## **SCOPING OPINION:**

# **Proposed Stanlow Hydrogen Ready Modular Combined Heat and Power Project**

**Case Reference: EN0110007**

**13 October 2026**

DRAWING NUMBER:
2026UK550445-ENV-001-SR-0501-P01-S0

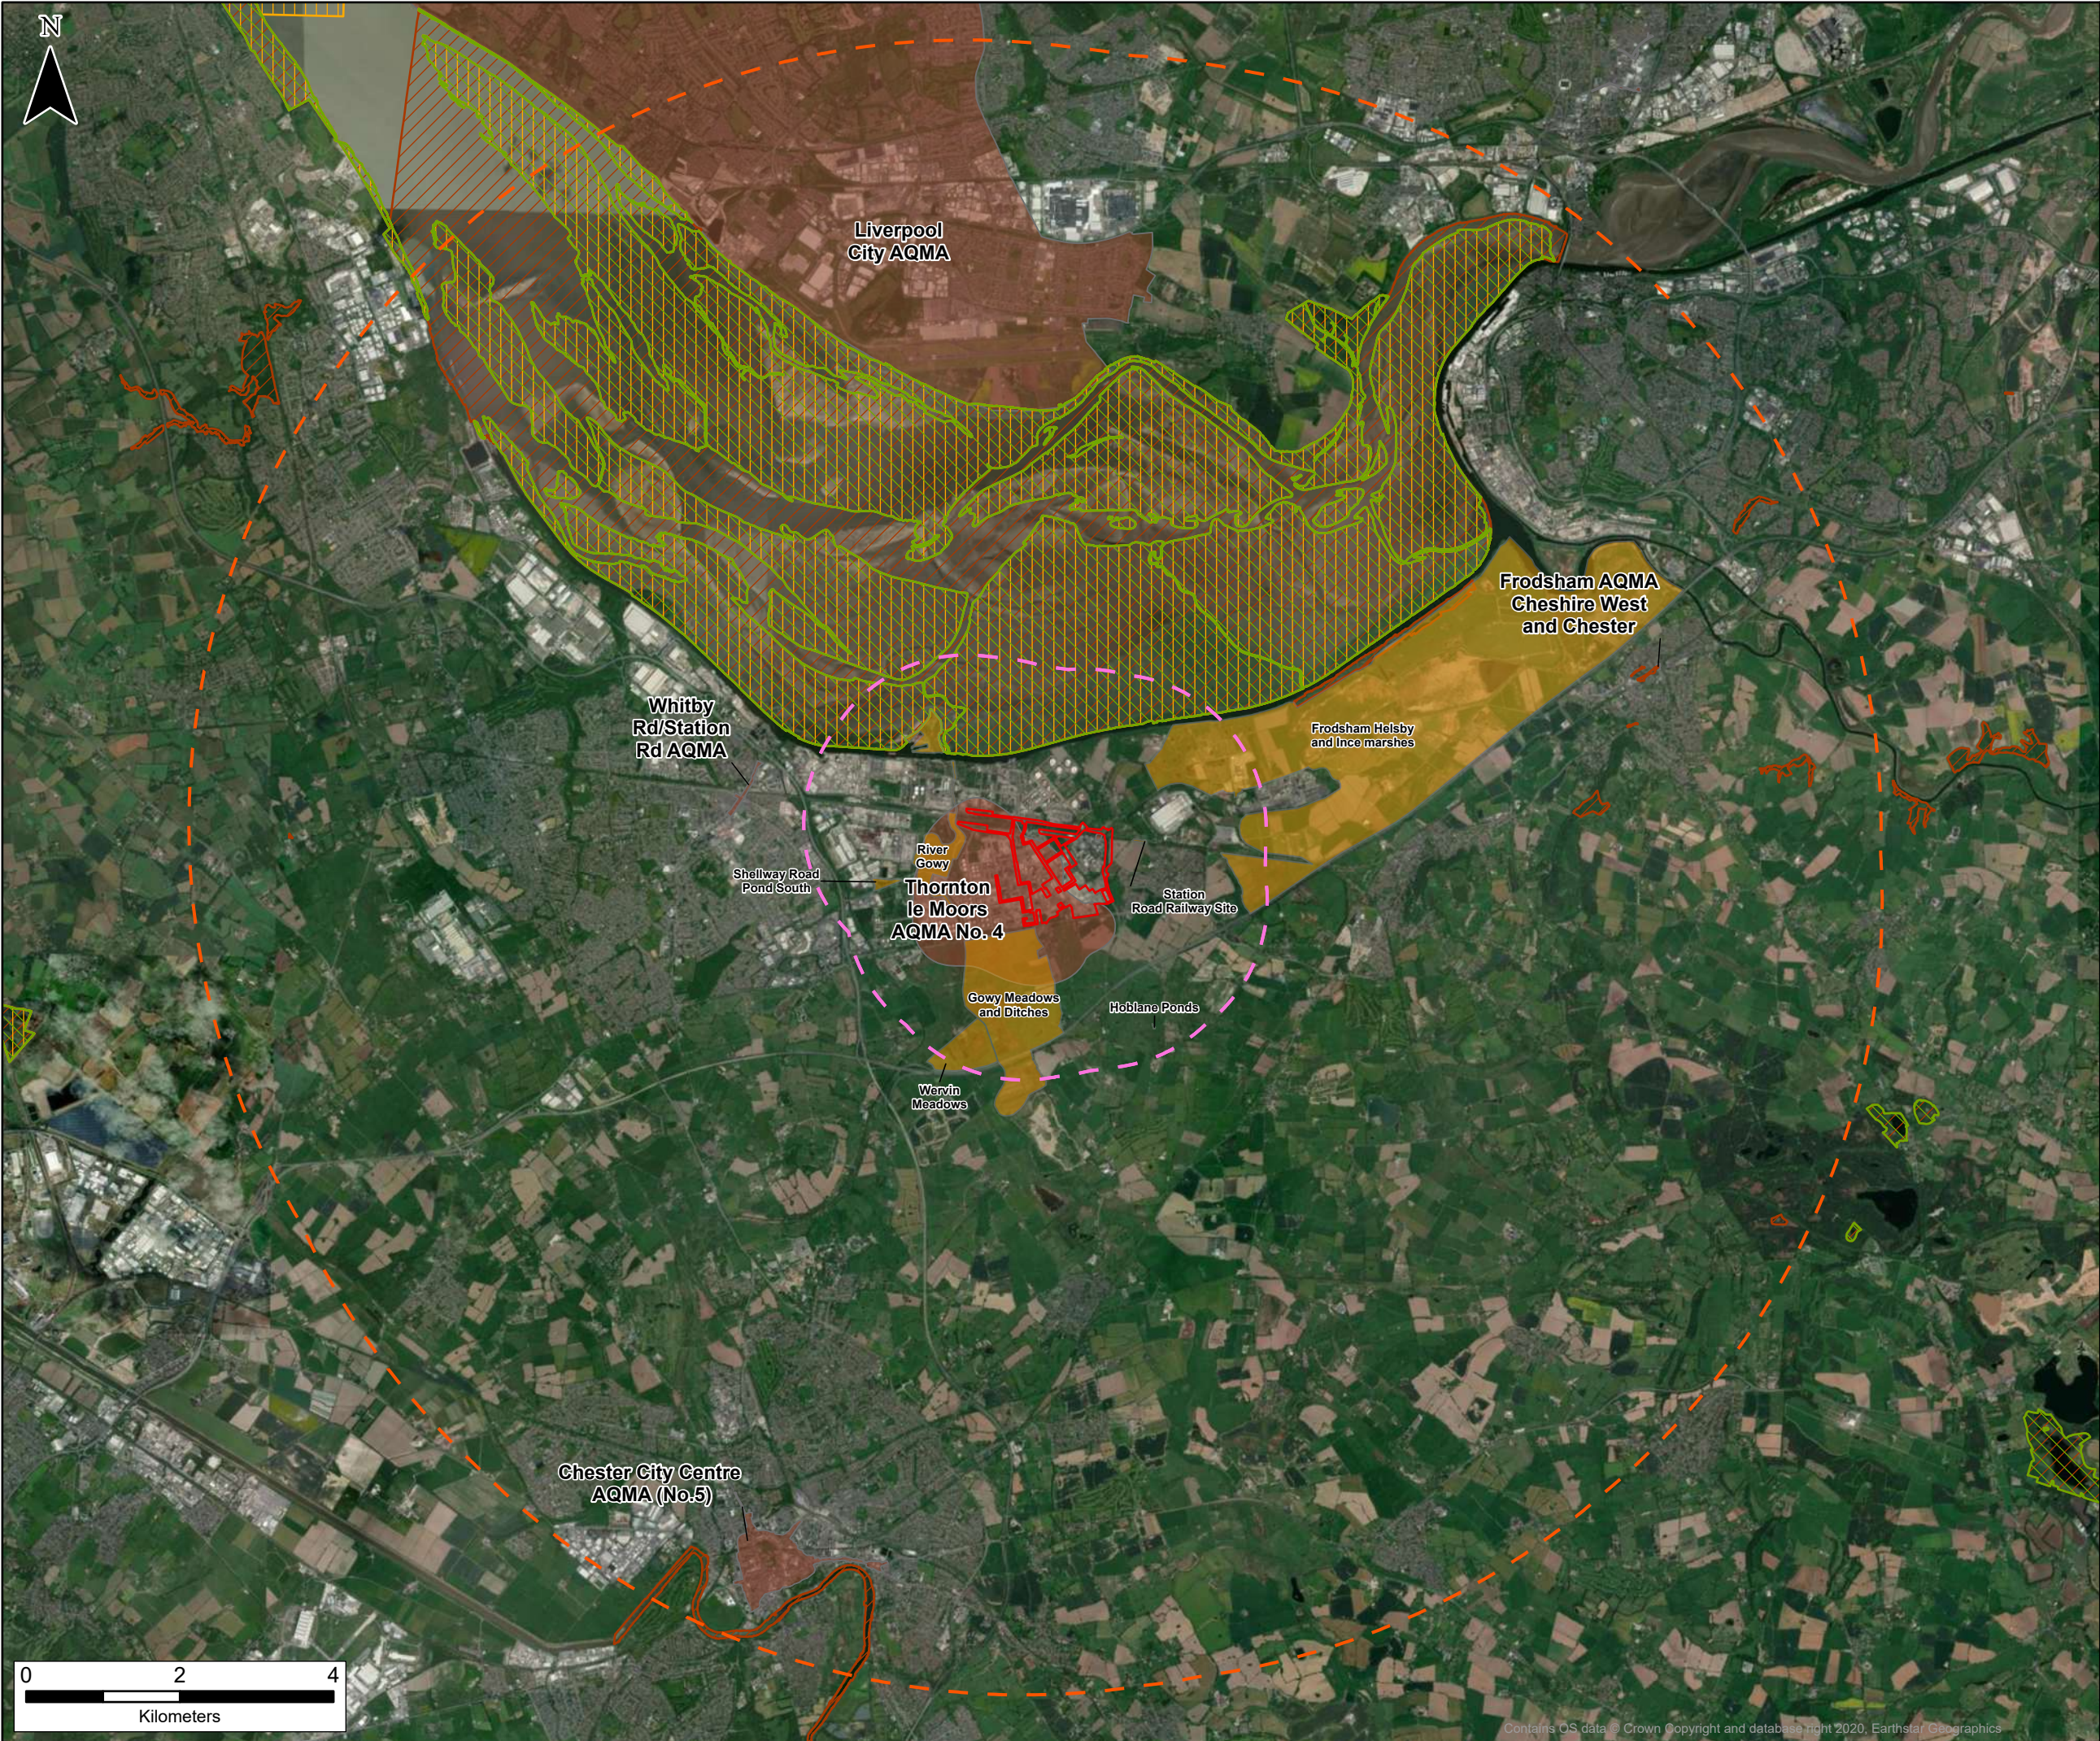
| ID    | Ref                                  | Description                                | Inspectorate's comments                                                                                                                                                                                                                                                                                                                                                                                                                                                                                                                                                                                                                                              |
|-------|--------------------------------------|--------------------------------------------|----------------------------------------------------------------------------------------------------------------------------------------------------------------------------------------------------------------------------------------------------------------------------------------------------------------------------------------------------------------------------------------------------------------------------------------------------------------------------------------------------------------------------------------------------------------------------------------------------------------------------------------------------------------------|
| 3.2.5 | Paragraphs 5.5.18, 5.6.4, figure 5.1 | Sensitive receptors                        | The Scoping Report states that sensitive human receptors are located within 250 metres (m) of the site boundary and 50m of potential transportation routes. However, figure 5.1 only shows the location of sensitive ecological receptors in relation to the proposed development. The ES should be accompanied by an appropriate plan illustrating the location of sensitive human air quality receptors within the study area to aid understanding of the extent of effects.                                                                                                                                                                                       |
